Andrew Beattie - Planning Disaster!

The Issues Associated with the Design of the Proposed Relocation of the Berry Equestrian Centre

This submission concerns the impact of the proposed Foxground and Berry Bypass on the Berry Equestrian Centre which is located in North Street Berry.

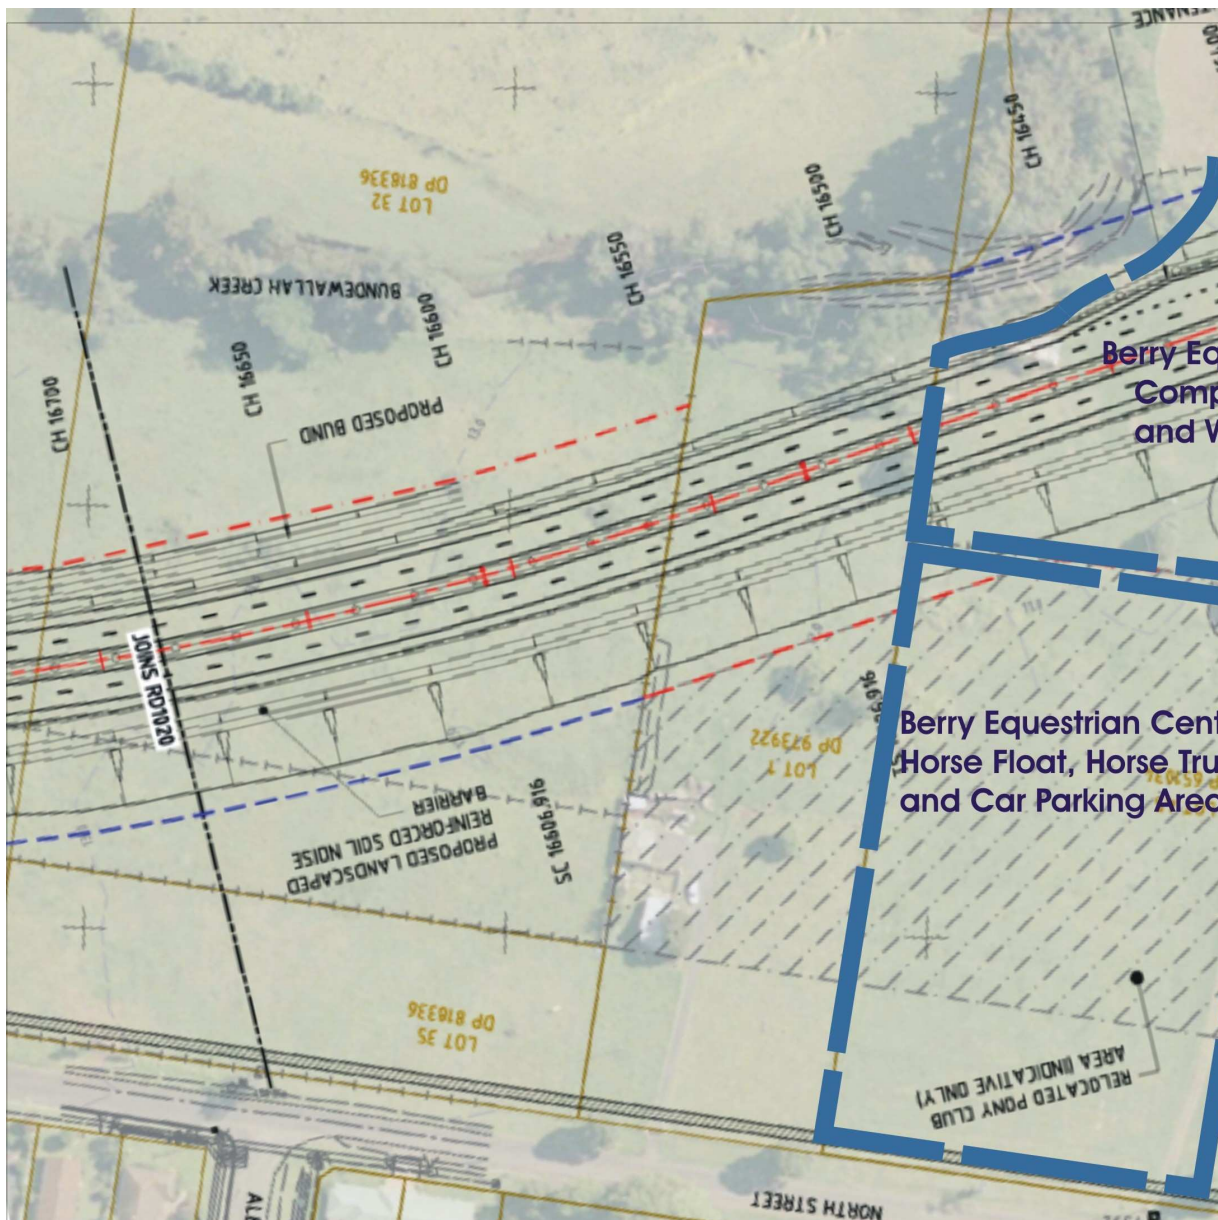
1. The competition grounds are required to be rectangular /square in shape of a minimum size of 140 metres x 140 metres with a level, well drained, good riding surface in order to cater for at least 4 dressage arenas or 2 showjumping arenas.

2. The parking area is required to be of a minimum area equivalent to 90 metres x 160 metres and allow for easy entry, maneuverability, parking and exit of horse floats and trucks. Each parking space is equivalent to an absolute minimum of 4 normal vehicle spaces due to the need for unloading/loading and tie up areas for horses.

3. There is concern for the safety of horses, riders and the general public due to the near location of the proposed riding area to the 4 lane expressway, the skateway, the public cycleway/walkway and North Street. There will be anticipated significantly increased noise and visibility of cars and trucks travelling at 100km/hour on the expressway with horses competing nearby, often with young, very inexperienced riders.

4. Access to the grounds is likely to be across a public shared cycleway/pathway. The safety of children on skateboards, bicycles etc are at risk as horse trucks and floats cross the pathway. Horse floats and trucks also require an indented driveway of at least 15 metres to allow vehicles to park off the roadway whilst gates to the grounds are opened.
